Reference No:	2024/60/90137/E
Site Address:	adj, 18, Ullswater Close, Dewsbury, WF12 7PN
Description:	Outline application for erection of 1 dwelling
Recommending Officer:	Nicole Helliwell

DECISION - REFUSE

Officer Report

Proposal: Outline application for erection of 1 dwelling

DRAWING TITLE
Proposed Elevations

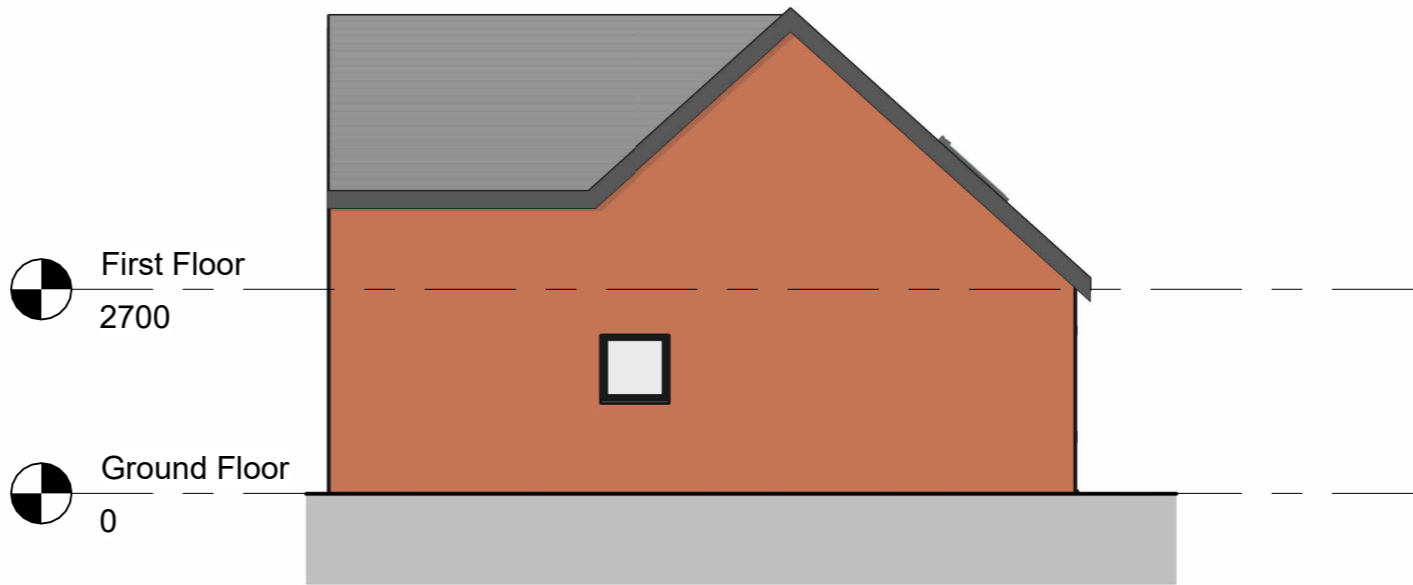
The proposed dwelling would be two storeys in height and would be of a contemporary design. The property would be faced in red brick and would incorporate a dual-pitched roof finished in grey pan tiles to match the appearance of the surrounding properties. The dwelling would also feature roof lights within the front roof plane and a dormer extension within the rear roof plane. As it is not clear from the submitted plans and information, it is considered appropriate to impose a condition should the application be approved requiring the rear dormer extension to be faced in grey pan tiles.

The submitted plans and application form also provide limited information regarding the proposed boundary treatments. Therefore, in the interest of visual amenity and to ensure that a satisfactory appearance of development is achieved upon completion, a condition will be imposed should the application be approved requiring details of the position, height, and materials of all boundary treatments to be submitted to and approved in writing by the Local Planning Authority.

Proposed Site Plan

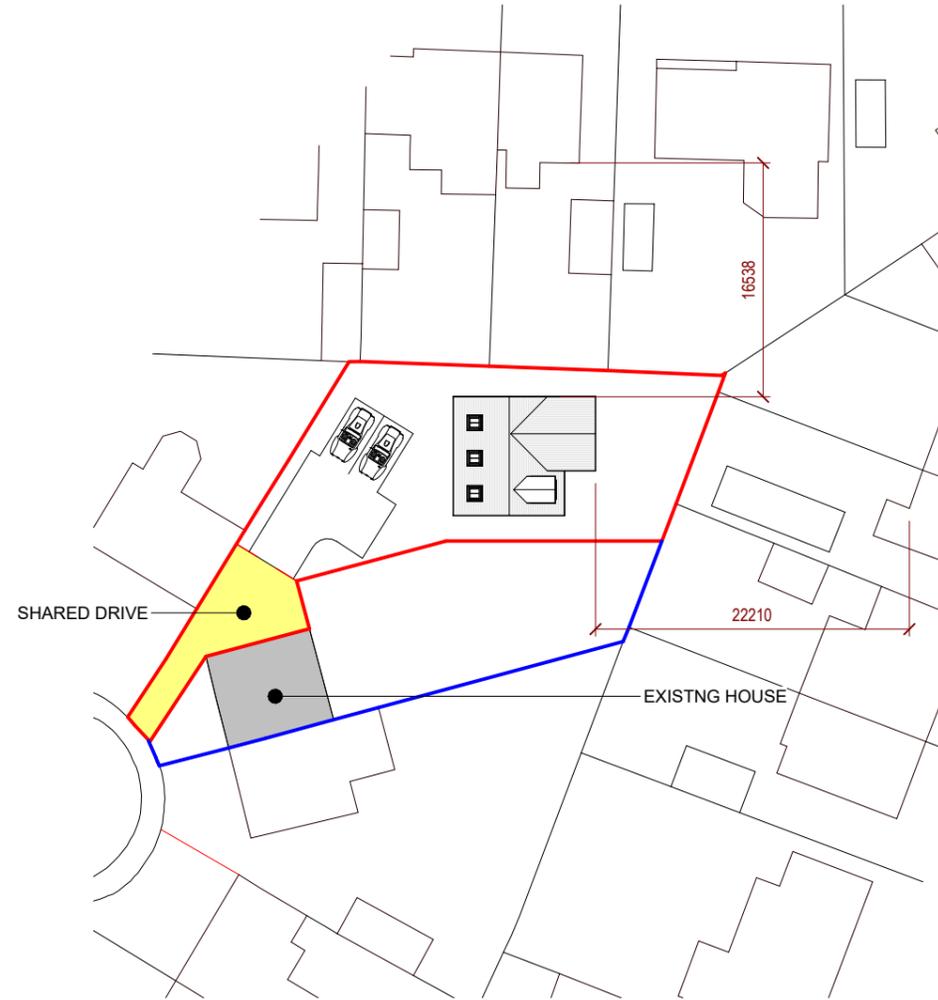
The proposed dwelling would orient towards the west and would not continue an existing building line. The dwelling would be set back approximately 26.7m from Ullswater Close which would reduce its prominence and visibility from public vantage points. However, it is considered that the detached property would be an infill development and would appear as a standalone feature that would fail to sympathetically integrate with the neighbouring properties. The proposal would introduce an incongruous layout in the street scene which would be out of keeping with the character of the area.

18 Ullswater Close is a two storey semi-detached property located south-west of the application site. It is noted that a distance of approximately 1.8m would be retained between the side wall of the proposed dwelling and the common boundary shared with no.18. Although this would fall short of the recommended separation distance, it is noted that the proposed dwelling would contain no fenestration within its side elevation. Furthermore, the proposed development would occupy a position approximately 13m from the rear elevation of no.18. However, it is considered that there would be no significant detrimental overshadowing, overlooking or overbearing impact on the neighbour's residential amenity given that it would not have a direct relationship with the proposed dwelling.

9 and 11 Ullswater Road are residential properties located north-west of the application site. The submitted site plan confirms that the proposed dwelling would occupy a position approx. 16.5m to no.9 and approx. 18.4m to no.11, which would accord with the separation distances outlined within the SPD. On this basis, it is considered that there would be no significant detrimental overshadowing or overbearing impact on the neighbour's residential amenity. Furthermore, it is noted that the proposed dwelling would include a new ground floor window within the north-facing side elevation. Although this window would serve an open plan kitchen/dining/living area which is a habitable room, it would be of secondary use. Therefore, should the application be approved, a condition requiring the window to be obscure glazed will be added to the decision notice to prevent any detrimental harm to the neighbouring occupants with regard to residential amenity.

20 Ullswater Close is a two-storey detached property located west of the application site. The submitted plans indicate that the proposed dwelling would be positioned approximately 8.1m from the common boundary shared with no.20. Whilst the proposed dwelling would face towards the private outdoor amenity space of no.20, it would not have a direct relationship with the proposed dwelling due to the angled plots. For these reasons, it is considered that the proposed dwelling would not raise any significant concerns with regard to overshadowing/loss of light/overbearing impact.

The plans confirm that the proposed driveway width at 2.3m is substandard. The Kirklees Highway Design Guide states that to ensure residents can access their properties, a private drive serving five dwellings or fewer should be a minimum of 4.5m wide (5.0m wide if there are structures along its initial length for example walls) for the first 5.0m of its length. This is to allow vehicles to turn in and turn out. Furthermore, for a single dwelling a driveway should be at least 3m wide, or 3.3m if the drive provides the main pedestrian access to the dwelling. Therefore, the current driveway is unacceptable and would need to be widened to a minimum of 4.5m to be acceptable.

The applicant has stated that four off street parking spaces will be provided, two parking spaces for the proposed dwelling and two spaces for the existing dwelling. Whilst the parking spaces for the proposed dwelling would be acceptable, the parking spaces for the existing dwelling would use the shared access, effectively blocking the access to the new dwelling. As such, two parking spaces for the existing dwelling would need to be provided in an area that would not obstruct the shared access.

No bin storage areas are shown for either the existing or the proposed dwelling. Details of waste storage and collection for both dwellings should be provided. A waste collection/presentation point adjacent to the public highway would be required for the new dwelling due to the length of the driveway being over the recommended carry distance. The bin collection/presentation point should also be located adjacent to the public highway and must not obstruct the adopted highway or the access road for road safety reasons.

In view of the above, the site layout would not satisfactorily demonstrate that sufficient parking, turning and manoeuvring space would be available to serve both the existing and the proposed dwelling.
